PARC CALON GWYRDD LIMITED

LAND AT ROVER WAY

PRE-APPLICATION CONSULTATION REPORT

**REMOVAL OF FILL MATERIAL AND CONSTRUCTION OF
INDUSTRIAL ACCOMMODATION (B8 USE CLASS), NEW
ACCESS ROADS AND ASSOCIATED LANDSCAPING
WORKS**

00 - Proposed Site Plan
1 : 2000

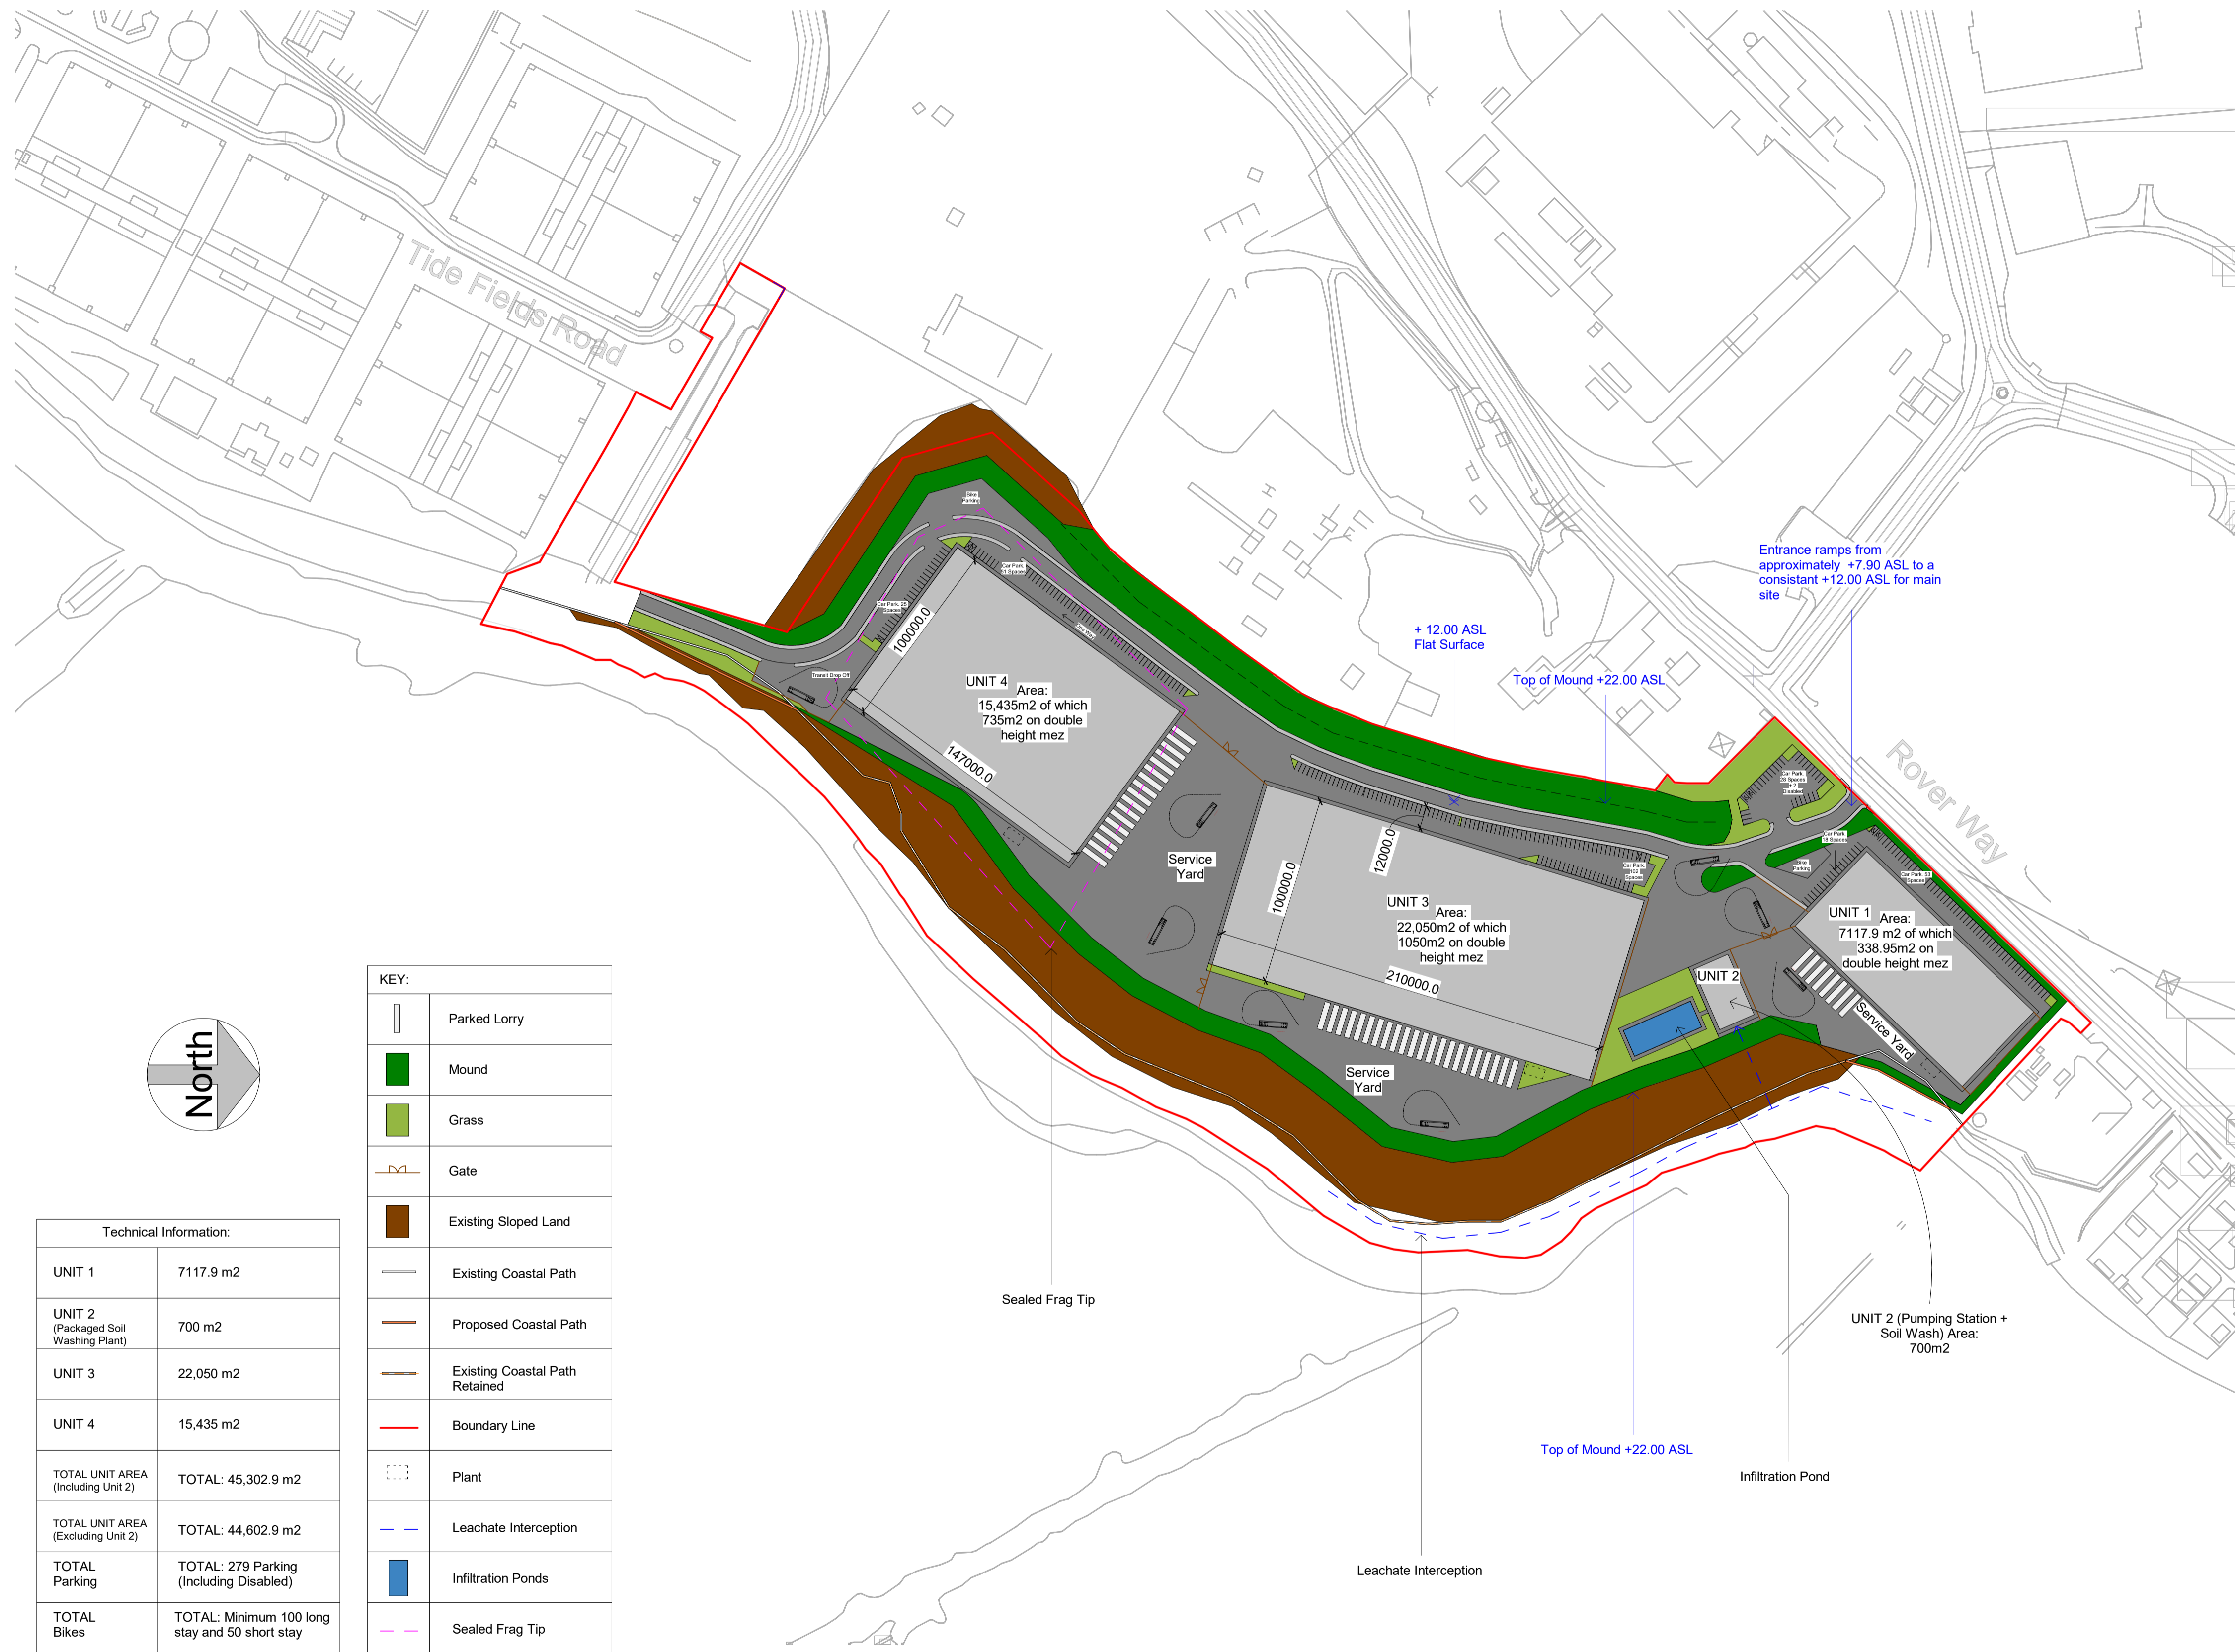
16/08/2021	Public Rights of Way	<p>Having looked over the site plans, the Wales Coast Path which is also a Public Right of Way, Sploft No.1, appears to be retained on the general alignment. The end locations appear to be a bit strange, however, in how the site is designed as the footpath is taken into the compound. The footpath would have to cross the bund on the eastern side as well so a rethink on how this is going to work is needed. There are a number of issues in the vicinity for vandalism and fly tipping therefore we would have expected the footpath to stay outside of the compound and road network for their own site security. It also means the footpath can be retained within a green corridor. It would be useful to have the footpath overlooked at the end points so that it isn't hidden away creating areas of antisocial behaviour/vandalism.</p>	The response is noted.

Date	Consultee	Representation	Response
		<p>Coast Path (WCP) will be re-routed and users of the path will be less screened than at present.</p> <p>However, it is unclear from the submitted Proposed Site Plan and Proposed Site Sections plans if engineering works will result in the WCP being located so to cause breaks in the skyline during pedestrian use. The location of WCP and the coastal bund should be clarified to establish where breaks in skyline are located. We also note paragraphs 8.4.20 and 8.5.10 refers to previous studies used for determining locations of birds relative to the site. Paragraph 8.5.30 also refers to bird movements / behaviour which are not referenced with a source. We advise the studies that inform these comments are submitted in support of your planning application, thus providing the necessary justification regarding their validity (e.g. in terms of age). Mitigation and Enhancement We provide the following advice regarding the Proposed Mitigation and Enhancement which is likely to need to be secured through the planning permission and referenced in any Habitat Regulations Assessment (HRA) prepared by the planning authority. Further advice on the HRA is set out below. Working Method We agree working methods will need to be agreed and secured through a planning condition. These should avoid and mitigate risk of disturbance to estuary species. Construction Environment Management Plan (CEMP) We agree the provision and submission of a CEMP. We advise you to refer to NetRegs GPP5 'Works and maintenance in or near water'. Habitat Management Plan We note the reference to Habitat Management Plan to maintain habitat to meet the SINC qualification criteria and provide suitable habitat for the Brown-banded Carder Bee. We presume this will be controlled through condition. We would need to review the Plan to ensure any proposed mitigation does not conflict with features of the Severn Estuary SSSI, including the Brown-banded Carder Bee. Wildflower Mix We note the proposed use of wildflower mix. We advise that if wildflower seed mix is to be used, it should be of local provenance to avoid the introduction of non-native species, of species that are not suitable for the character of the site. We advise that seed mix should be as local as possible, such as that from Great Traston Meadows, run by the Gwent Wildlife Trust. Where possible vegetation should be allowed to regenerate naturally, as this may allow colonisation by salt tolerant species, such as those found in the salt marshes along the Rhymney River.</p> <p>Pollution Prevention – Conditions 1-6 We note submission of the following chapters of the Environmental Statement submitted in support of the application:</p> <ul style="list-style-type: none"> • Chapter 7 - Geotechnical Conditions and Contaminated Land • Chapter 11 - Hydrology and Flooding <i>Drainage</i> <p>We note that foul water will be disposed of off-site into the local mains sewer network and this</p>

Finally, the applicant also considers that the Flood Defence scheme will have no impact on the development and that the proposals will not cause any change to the Coastal Path delineation.
